Case Ref: EN010119

Date: 22 August 2024

Planning Act 2008 (as amended) – Section 51

Application by North Falls Offshore Wind Farm Ltd for an Order Granting Development Consent for the North Falls Offshore Wind Farm Advice following issue of decision to accept the application for examination.

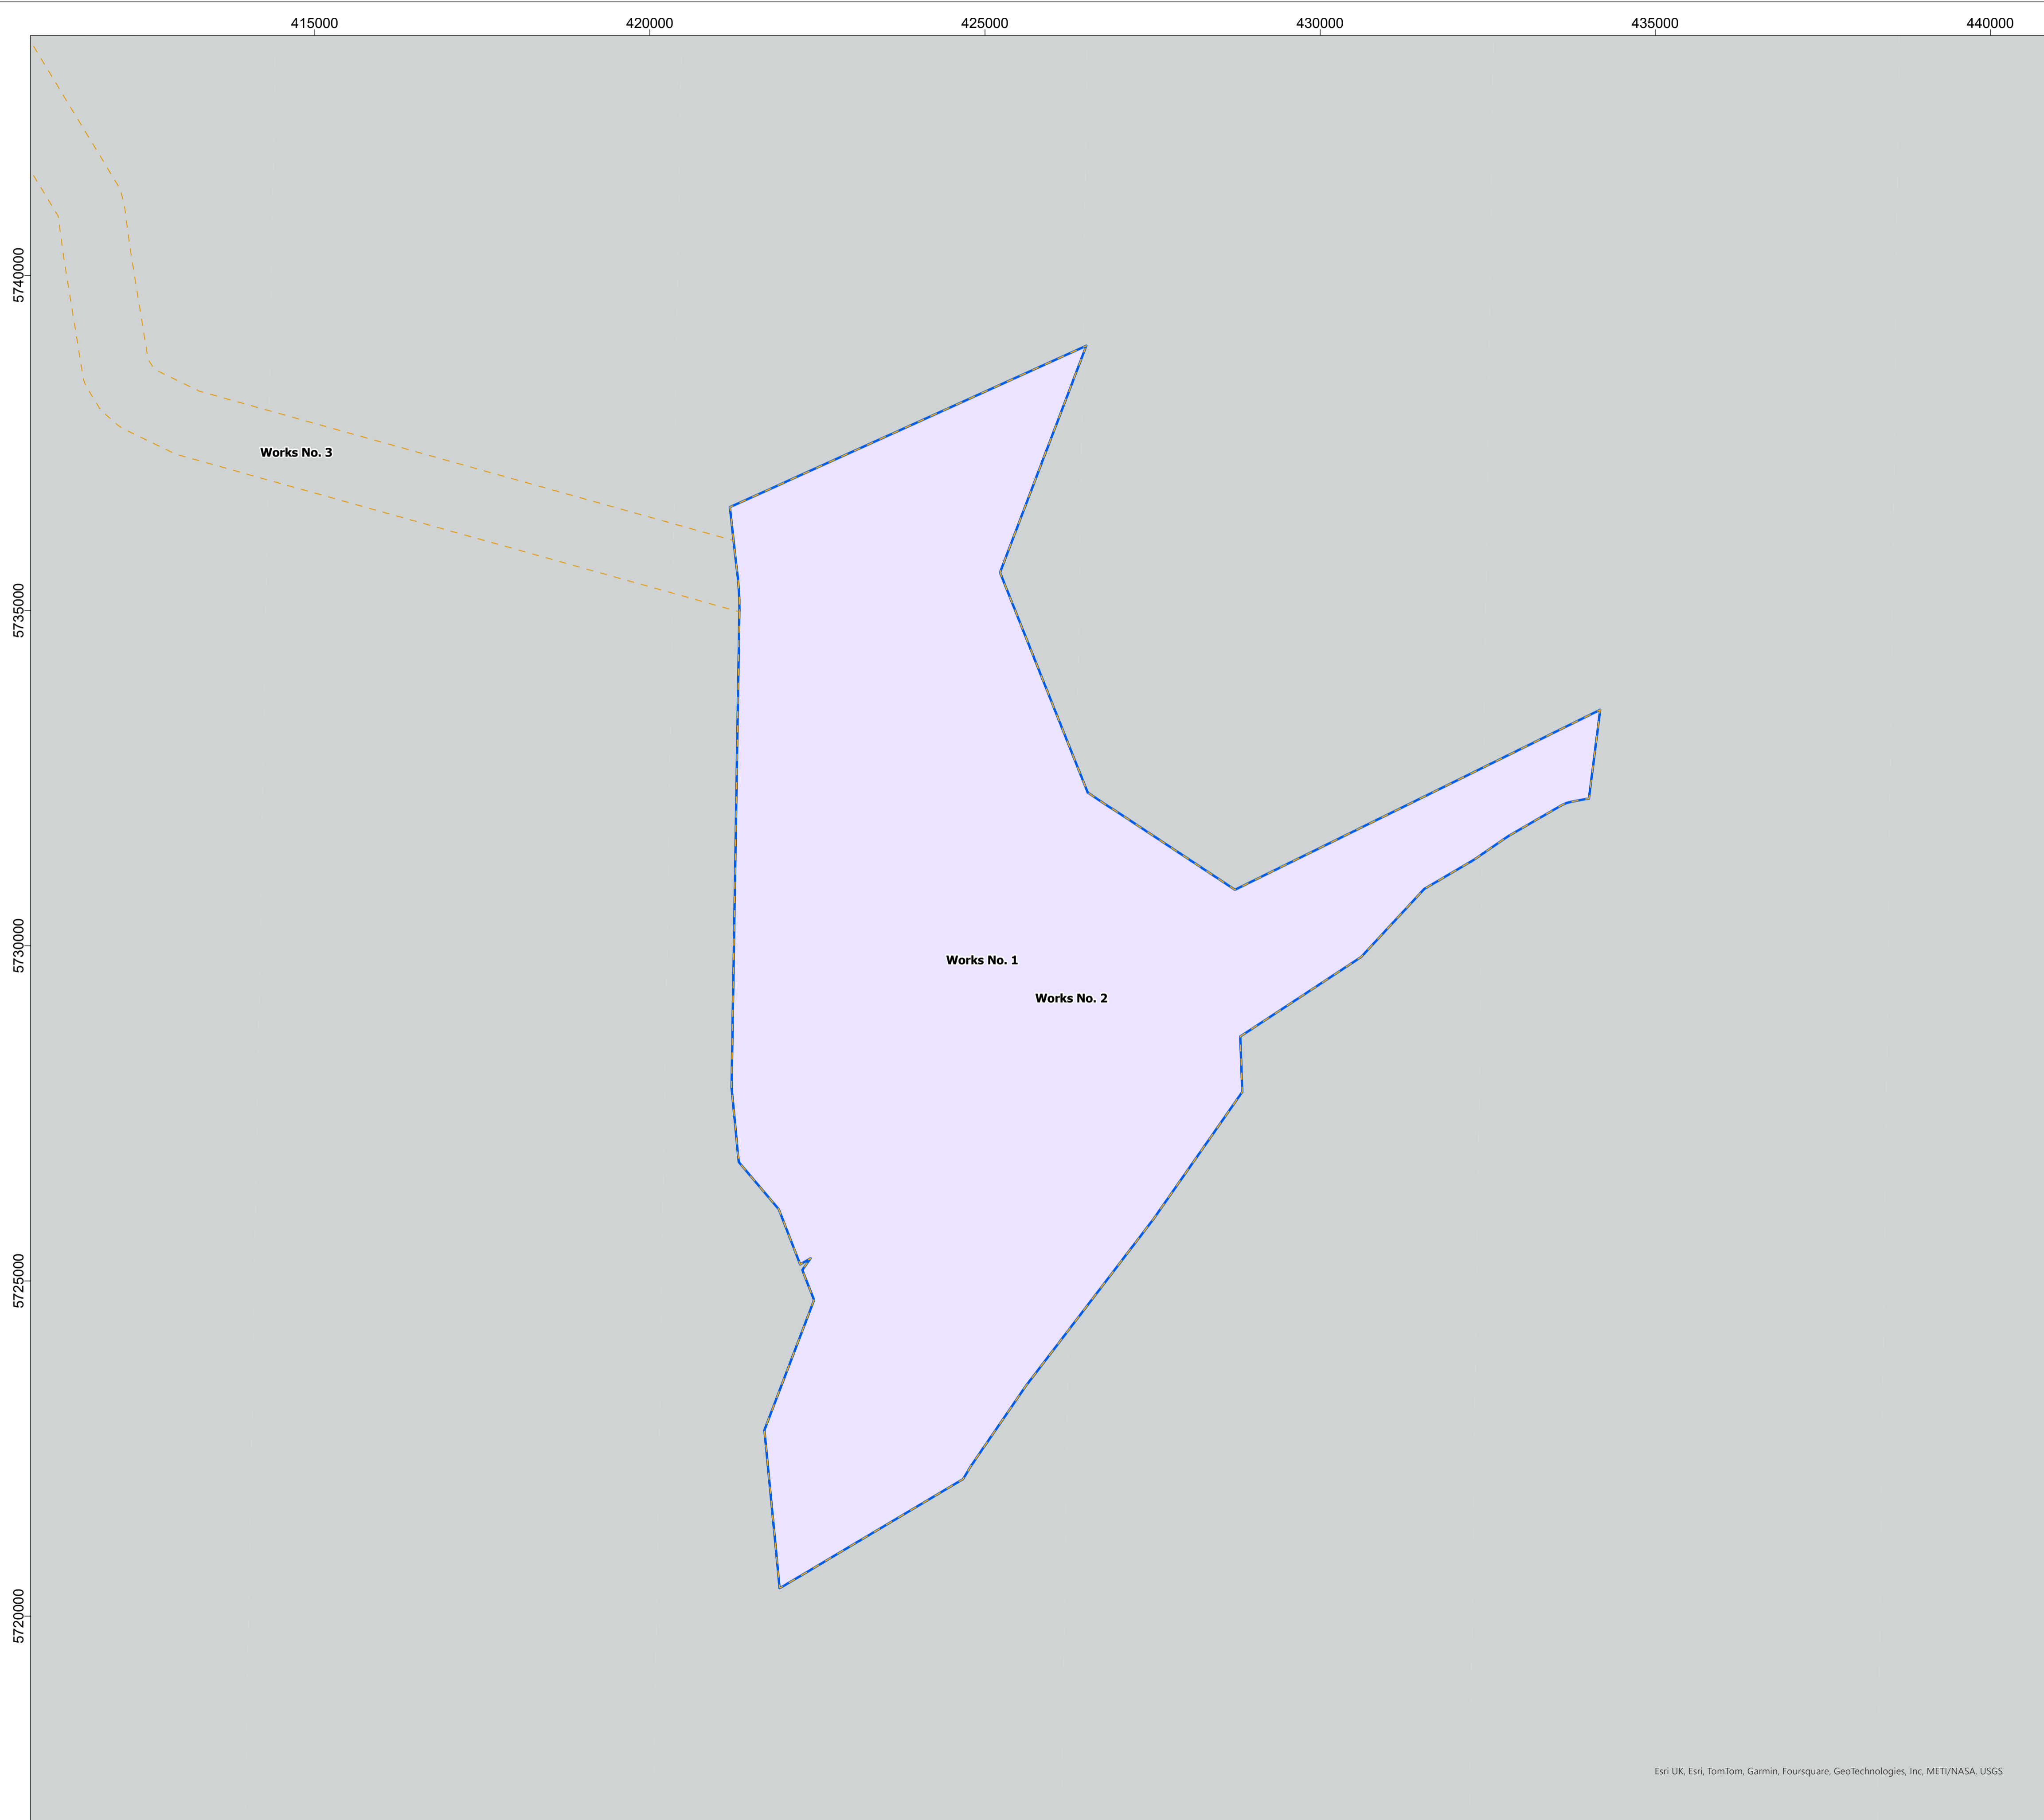
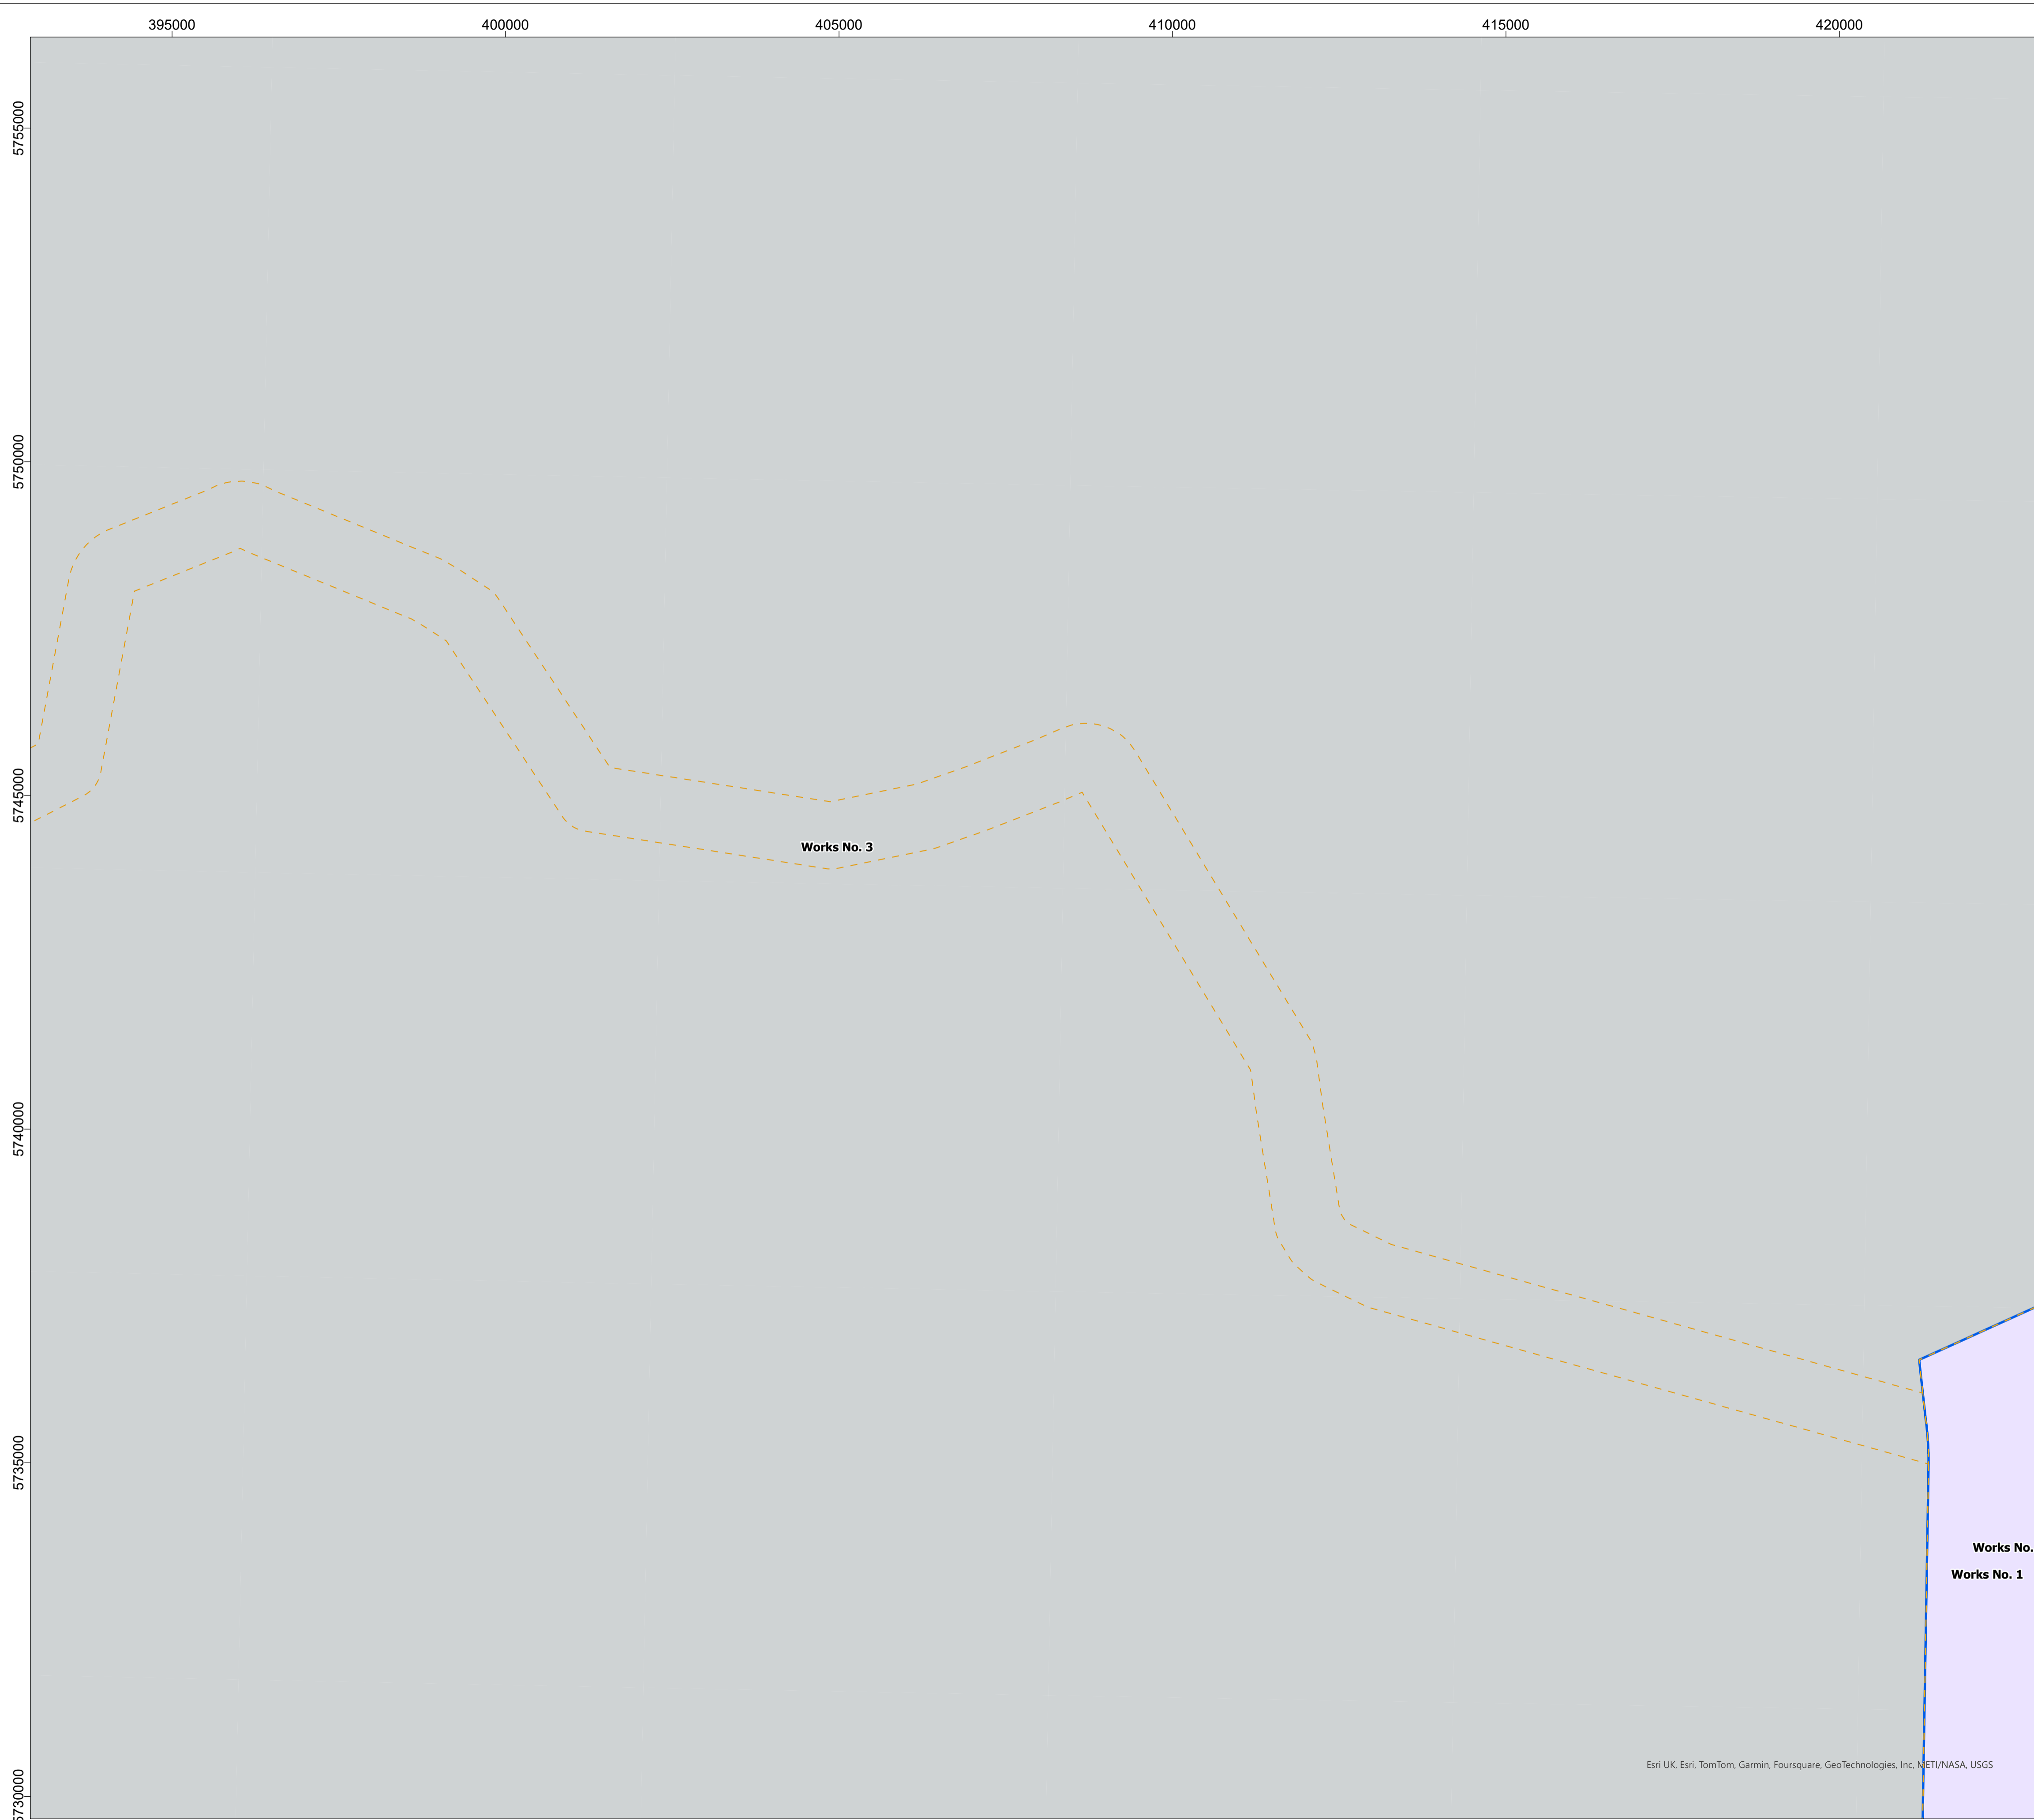
Summary descriptors are not provided for each work area. Location Plan Offshore (Doc. 5.2) includes a background reference map, however this is missing in the Works Plan Offshore (Doc 5.7). Adding summary descriptors and a background reference map would aid understanding for stakeholders. Once summary descriptors are added to the plans, please ensure that these can be digitally searched. This should be provided to the Planning Inspectorate for publication as early as possible before the commencement of the Examination.
